Consultation Response KC Landscape			
Planning Number:	2021/94304		
Proposal:	Discharge of conditions 20 (crime and anti-social behaviour), 23 (pedestrian connections) and 26 (landscaping) of previous permission 2019/90183 for erection of 14 dwellings and associated works		
Location:	Land off, Station Road, Skelmanthorpe, Huddersfield, HD8 9TT		
DEVELOPER/APPLICANT/AGENT:	Johnson Mowat Planning & Development Consultants		
Planning Officer:	Victor Grayson		
Date Responded:	13/12/2022	Responding Officer:	Diana Brown
Site Area (Hectares)	0.46ha	Responding Ref:	KK135

COND 26 – Details of hard and soft landscaping. **Landscape architect's response in yellow**

Scale @ A1	1:200	Date	02.12.20
Drawn	JL	Checked	
Drawing No.	SK-002	Rev.	D

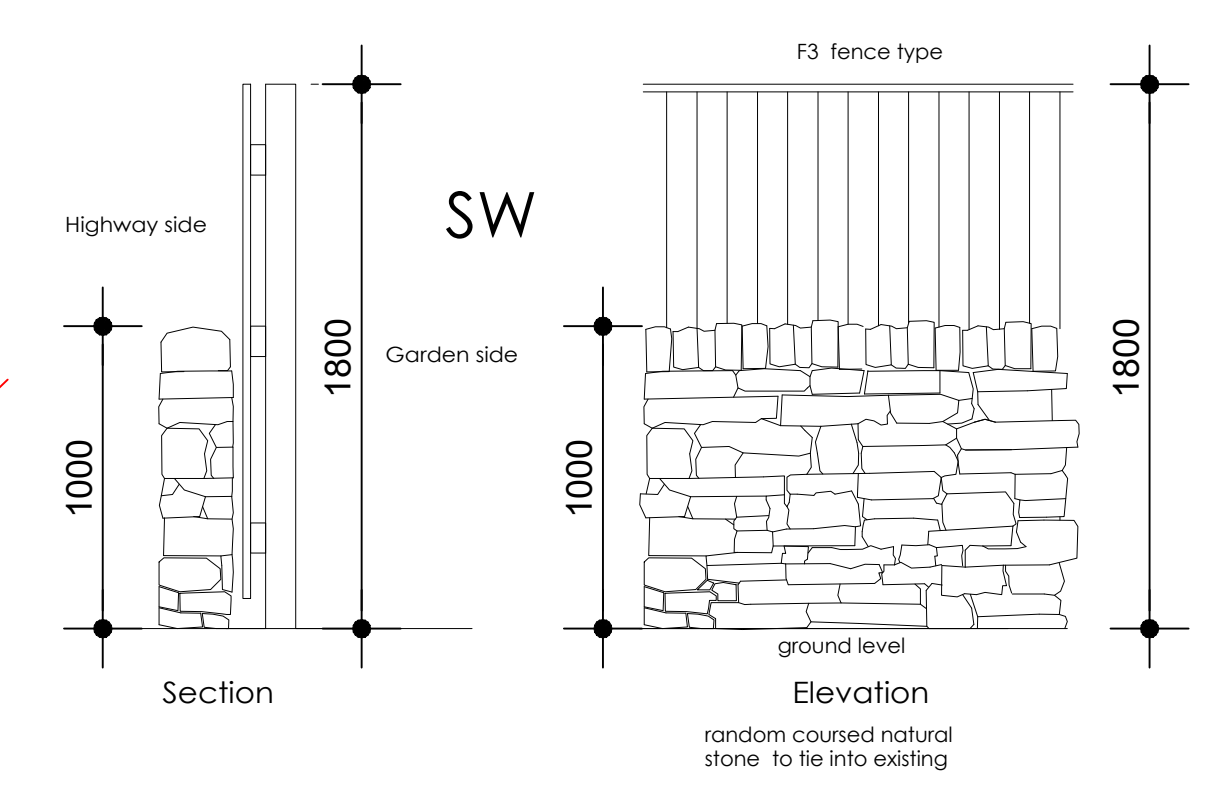
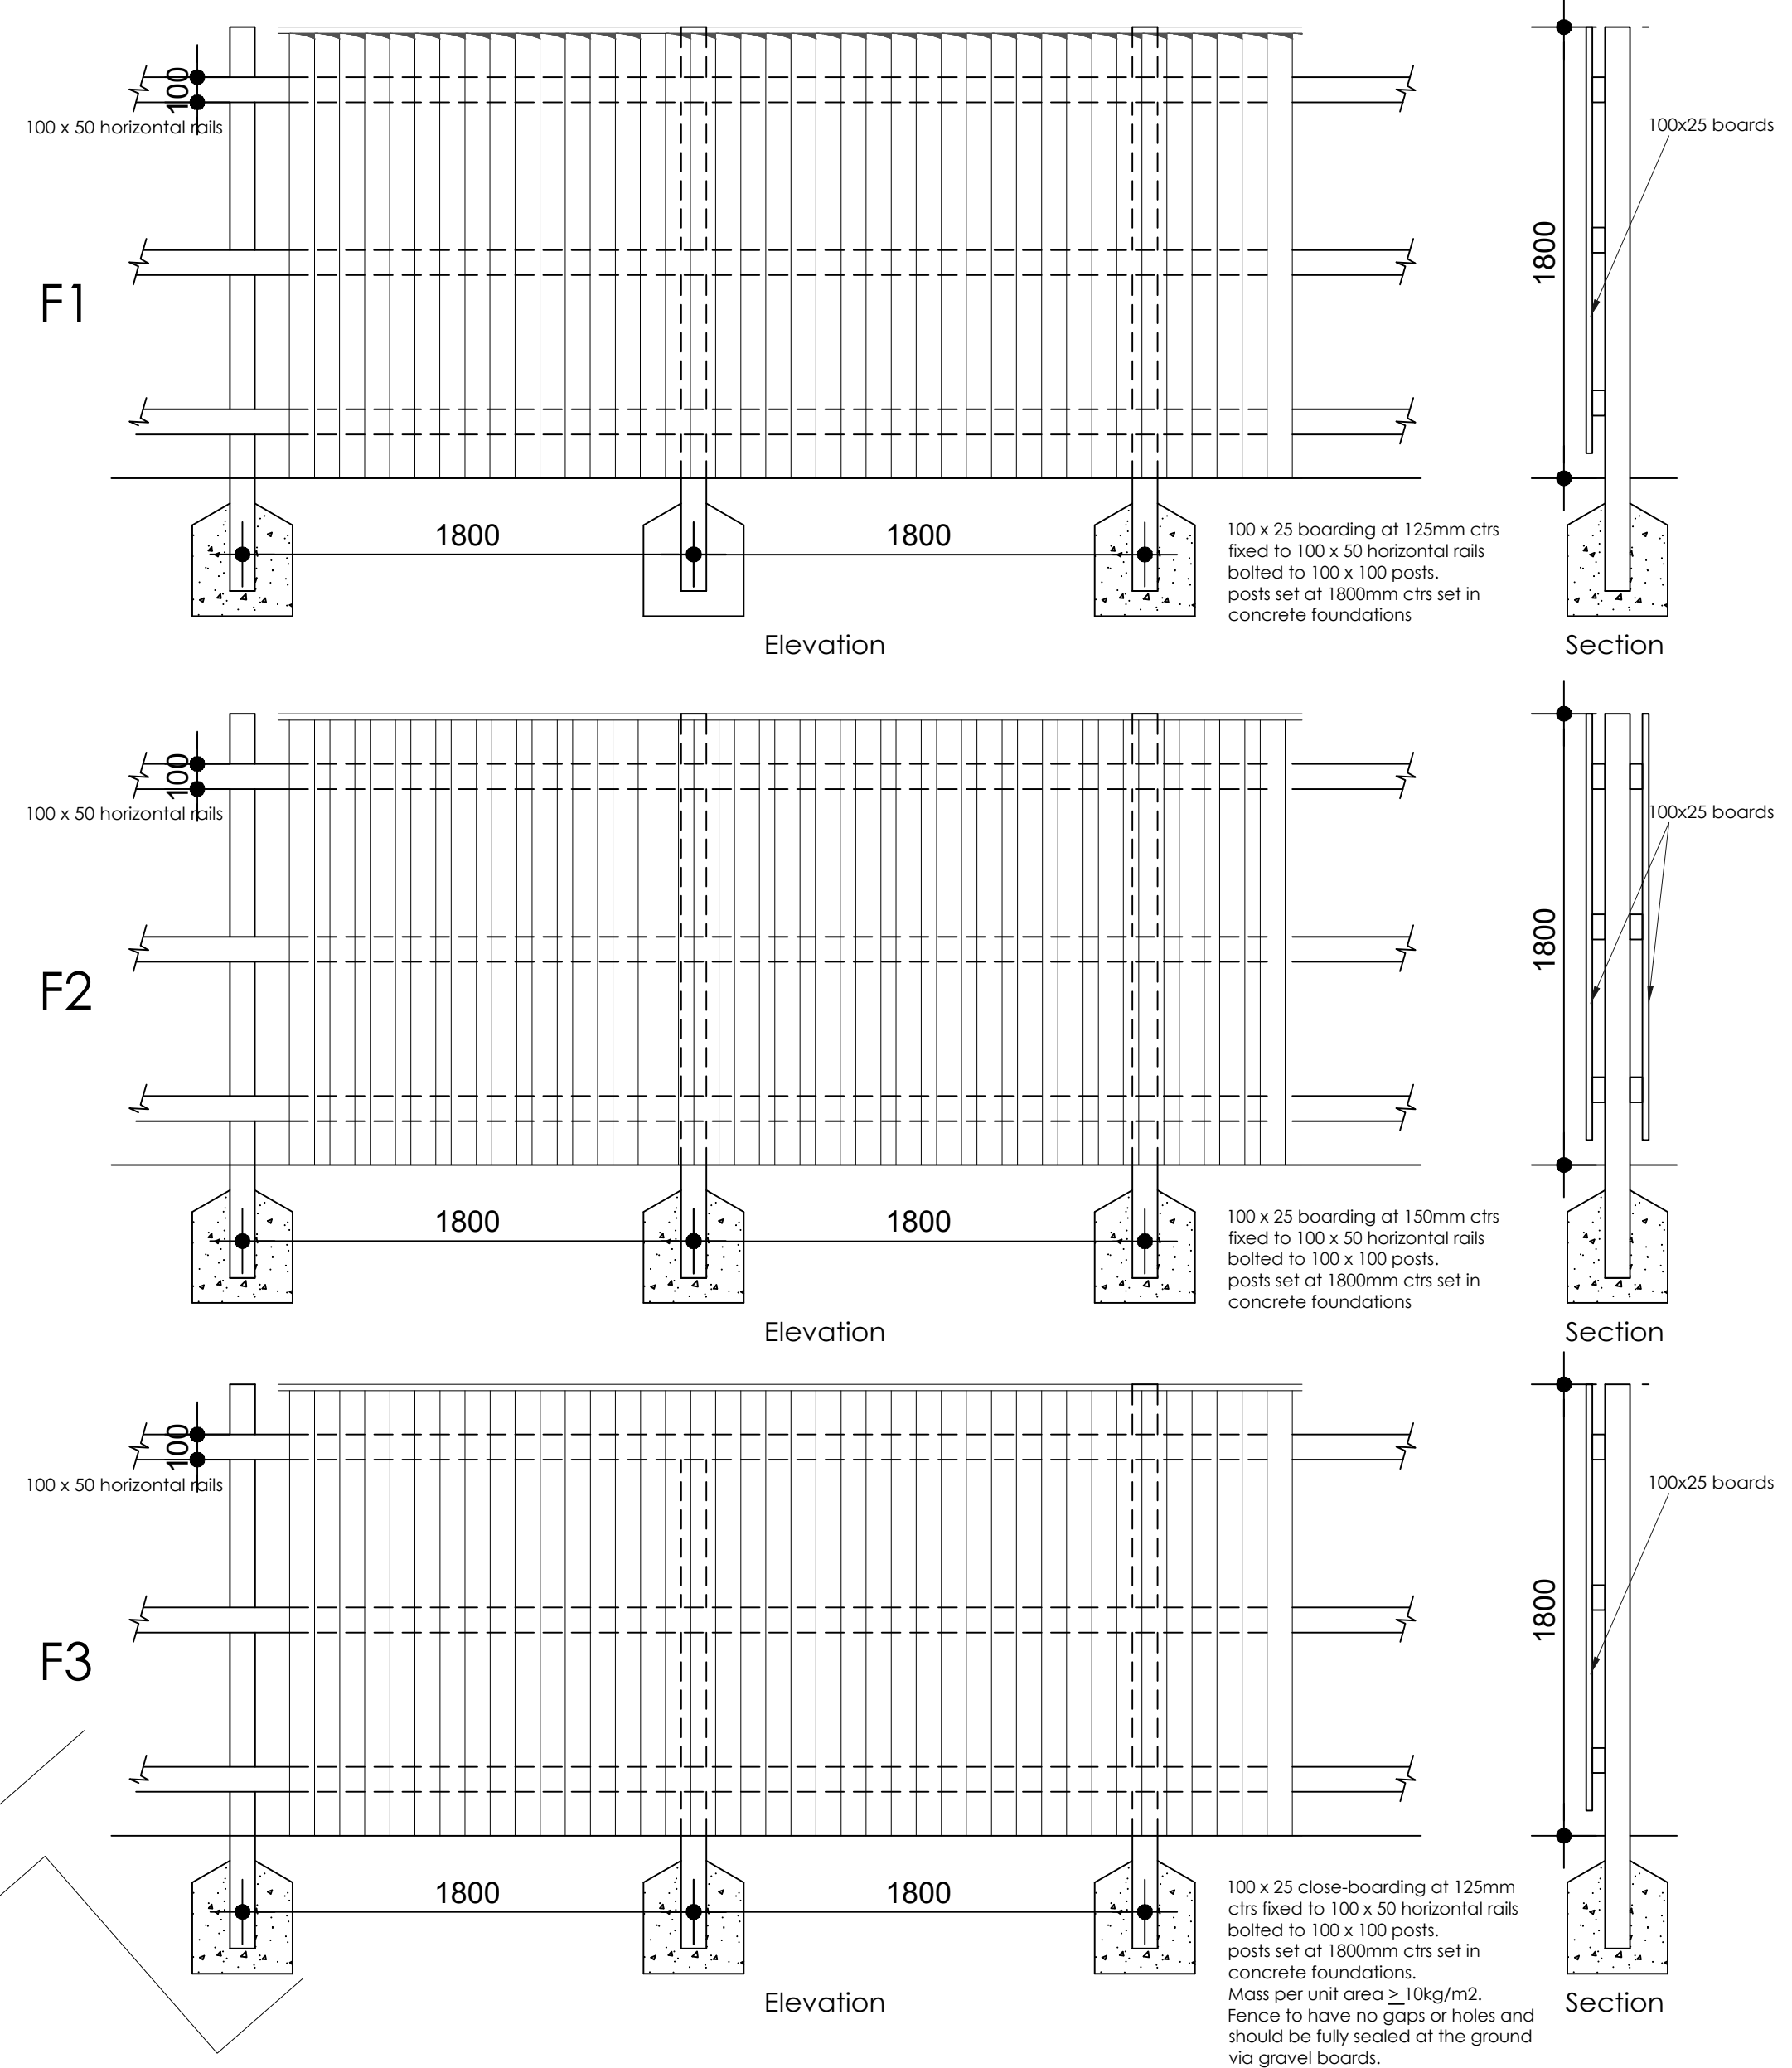
Clarification required as fencing detail provided does not include for hedgehog gaps.

CAD Ref:
CE-KR-1666-DW01 Final

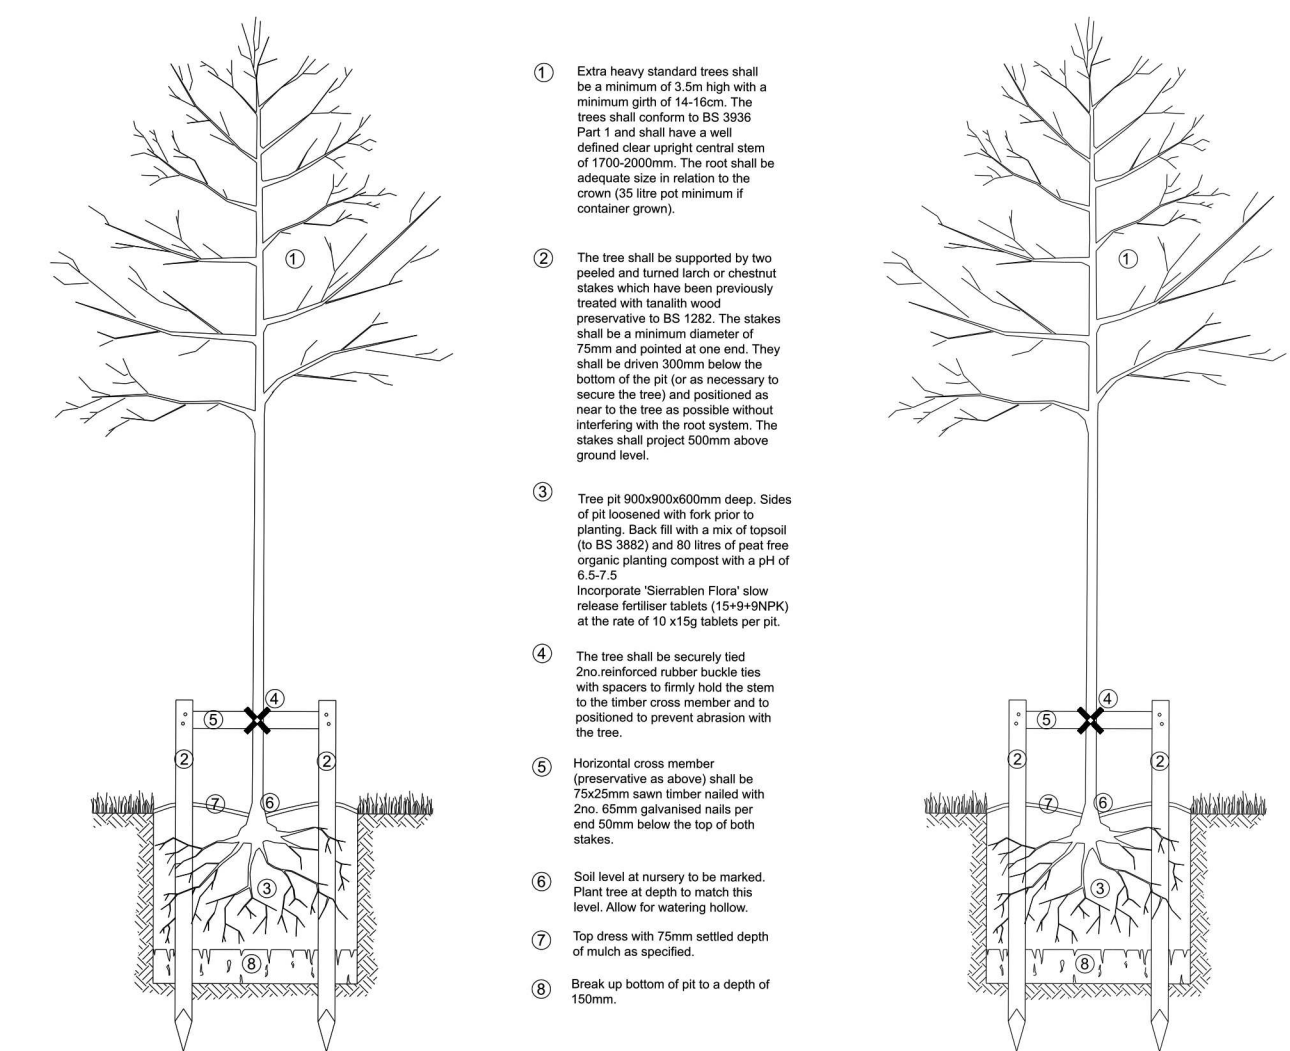
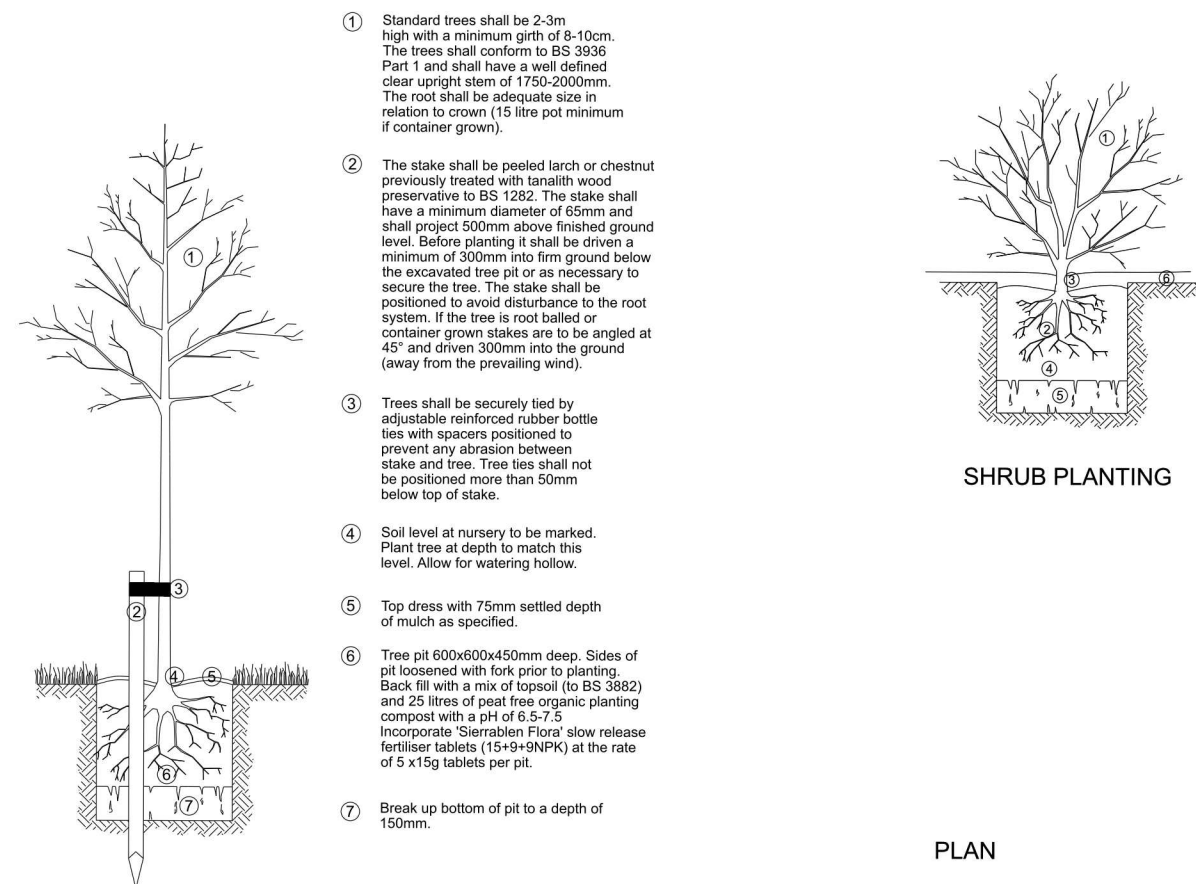
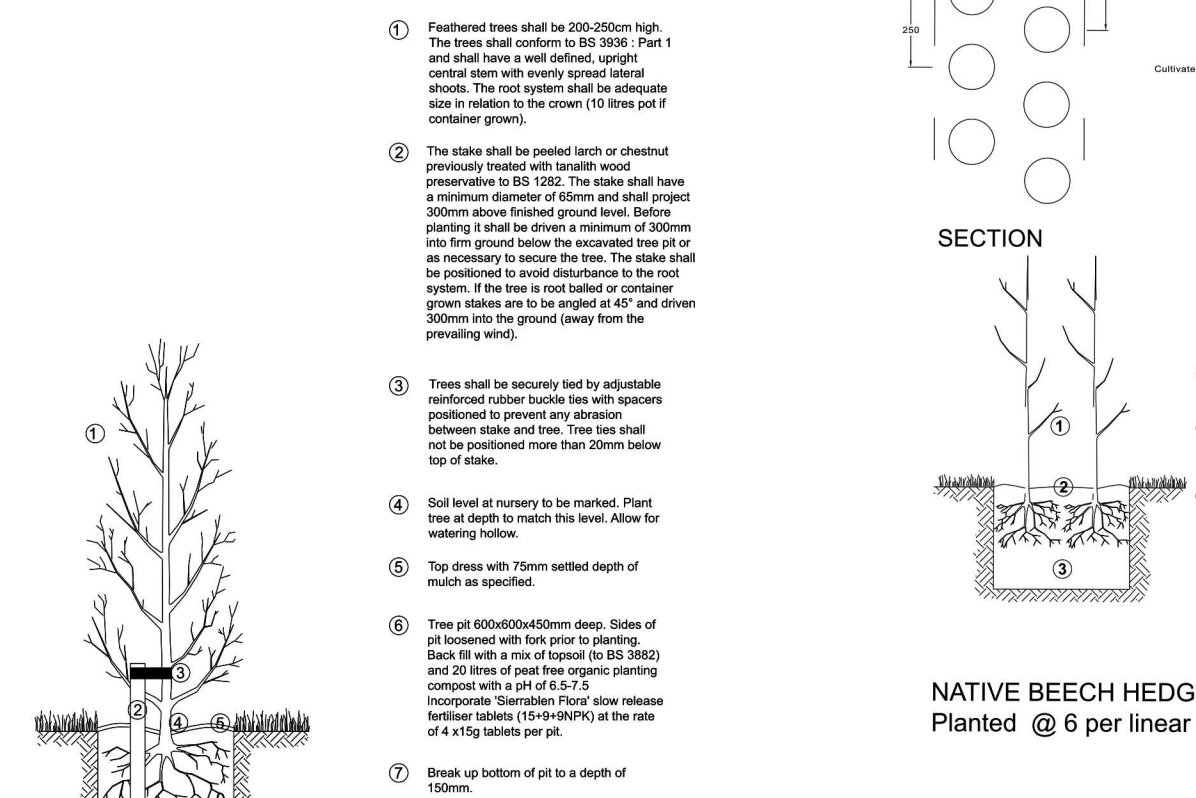
- e) Details of monitoring and remedial measures, including replacement of any trees, shrubs or planting that fails or becomes diseased within the **first five years** from completion; **Drawing No – See Dwg. No. CE-KR-1666-DW01 - Item 5.0 on drawing only says 12 months for defects replacement guarantee period – This should be five years.**

The planting plan list includes some potentially invasive species, which should not be planted in this setting given it's a rural location and near greenbelt. These plants should be substituted with more appropriate less invasive species.

Please substitute:

Alchemilla mollis Garden lady's-mantle
Cornus alba 'Elegantissima' ?
Cornus alba 'Kaseiringli'
Cornus alba 'Sibirica Variegata'
